From: >
Sent: 20 August 2026 18:03
To: DC Admin
Subject: Reference planning application 2025/93355 (Land off Woodward court)

Formal Objection to Planning Application

Highway Safety Concerns

Image 2.3 Proposed Hepworth Lane Site Egress

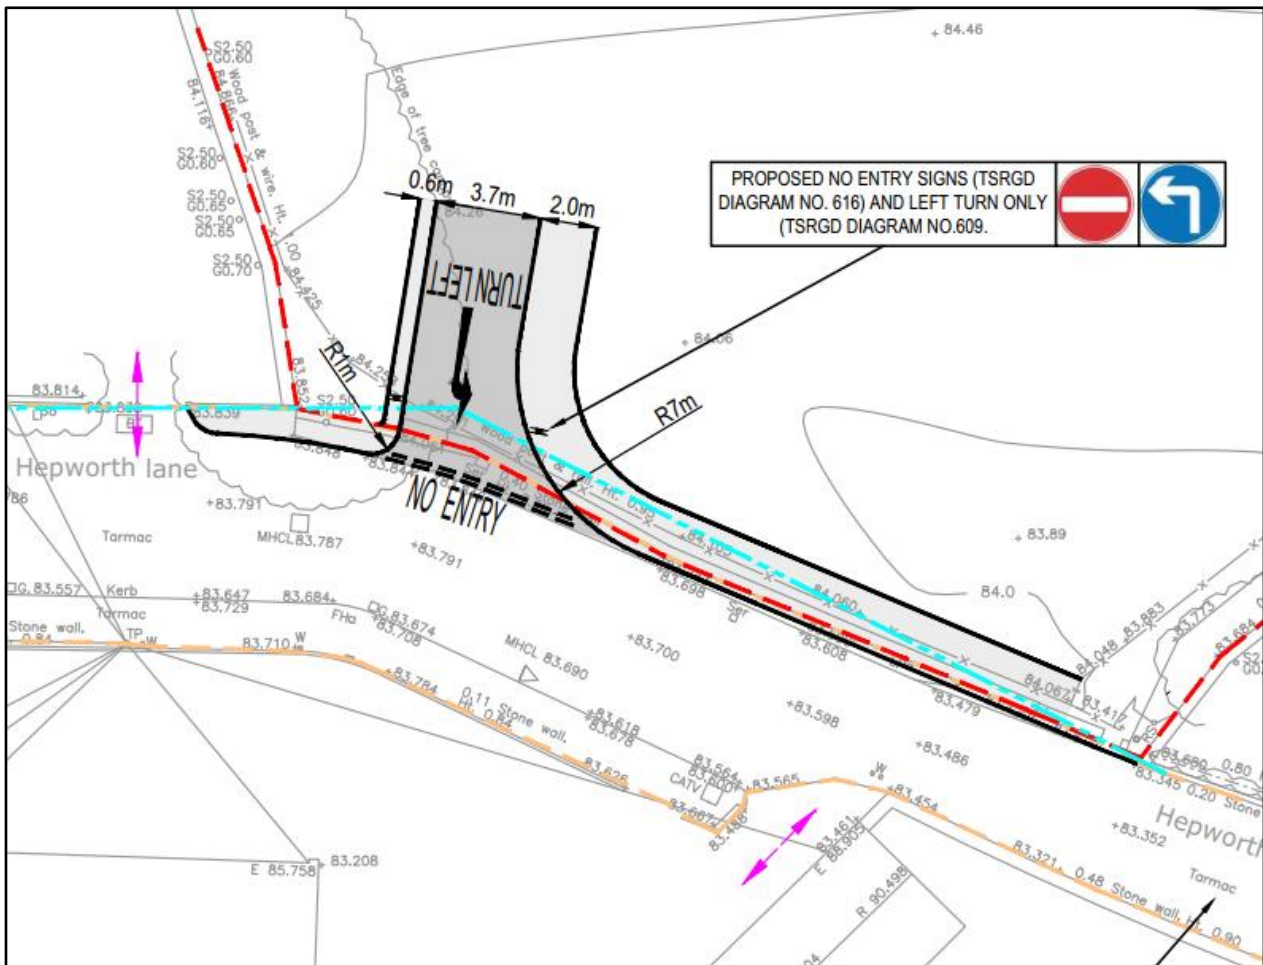
Dear Planning Officer, i wish to formally object to planning application 2025-93355 on the grounds of road and access safety. The proposal states that vehicles will exit onto Hepworth Lane with pedestrians and cyclists also using this access. This is a foot fare way for the children going to local schools.

Hepworth Lane is also a well- used walking route for children travelling to and from the local schools. Many Families use this route daily , and the increased vehicle movements would expose them to greater risk. The proposed short footpath section does not provide a safe, continuous pedestrian route or address the wider safety concerns for schoolchildren and older people living on the street using Hepworth Lane.

The applicant acknowledges that larger vehicles. such as refuse lorries or work lorries entering the site. will be unable to turn left or right when exiting because the junction is too restricted. This alone demonstrates that the access arrangement is fundamentally unsuitable. The Lane already suffers from limited width, visibility and no continuous pedestrian infrastructure. Adding more traffic, alongside pedestrians and cyclists, will inevitably increase the risk of conflict and accidents. The application itself notes that intensification of traffic on Hepworth Lane has previously been identified as unsuitable.

Yet no substantive highway improvements are proposed to address those known problems. A short section of footpath near the access does not resolve the inherent limitations of the lane, nor make it safe for increased traffic. For these reasons, i consider the proposal to present an unacceptable risk to motorists, pedestrians and cyclists. I respectfully request that the council refuse planning permission on highway safety grounds.
